# **PROPOSED EPPING SOUTH PRIMARY SCHOOL AT 86 CHELMSFORD AVENUE EPPING**

**Application Number: SSD-8873789**

## **Submission by residents of Second Avenue, Epping**

Figure 21 Proposed access points (Source: Pedavoli Architects)

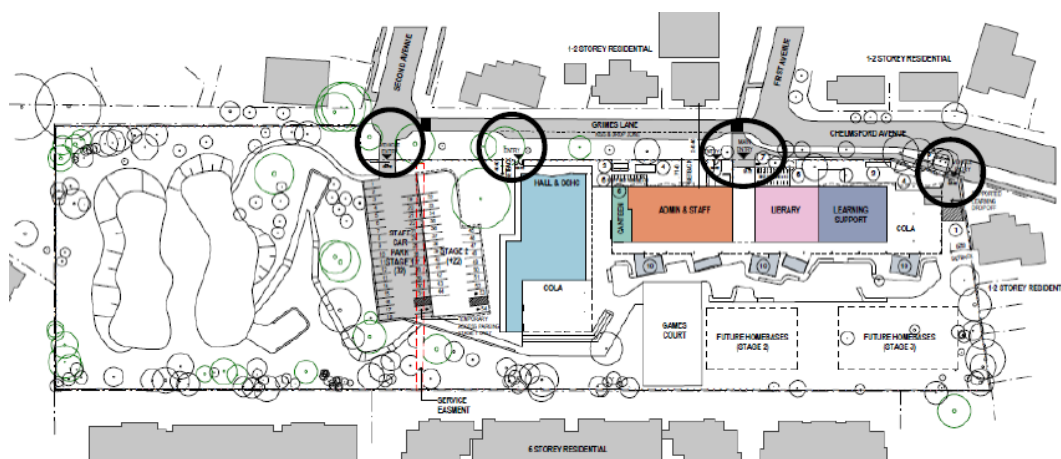
There seems to be no engineering or environmental problem in providing access to the proposed carpark from Grimes Lane instead of Second Avenue. This option would satisfy both school needs and the concerns of Second Avenue residents. Why the carpark was not located in the north eastern corner of the property to the left of the existing vehicular entrance seems incredulous.

Figure 30 Proposed civil works to Grimes Lane (Source: PTC)

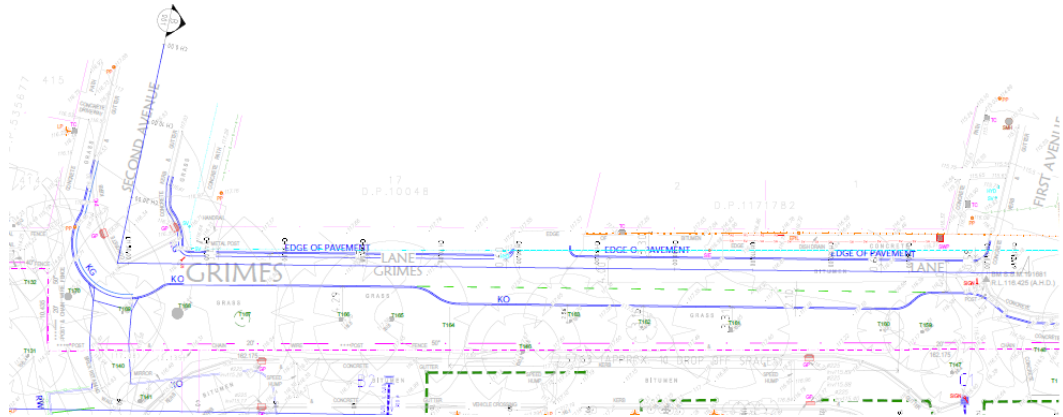
At present motor vehicle access between Grimes Lane and Second Avenue is physically denied by large wooden logs at the western end of Grimes Lane.

The denial of motor vehicle access between Second Avenue and Grimes Lane was officially implemented some decades ago. This was done at the request of Second Avenue residents to prevent the loutish actions of through traffic drivers from deliberately disturbing the tranquillity of Second Avenue residents 24/7. There is no objection to retaining existing pedestrian and cyclist access to and from Second Avenue.

Second Avenue will suffer a 24/7 increase in traffic generation by connecting Grimes Lane with Second Avenue. (See diagram Page 2 for alternative access proposals)

Grimes Lane is wide enough to accommodate two-way traffic, drop-off/pick-up facilities and at least a 2.0 metre wide footway adjacent to the school boundary. There is sufficient space to provide 90° angle parking for a kiss and drop zone so those motor vehicles can enter and leave via First and Chelmsford Avenues satisfying the needs of the school and Second Avenue residents. Angle parking at 90° will accommodate more vehicles.
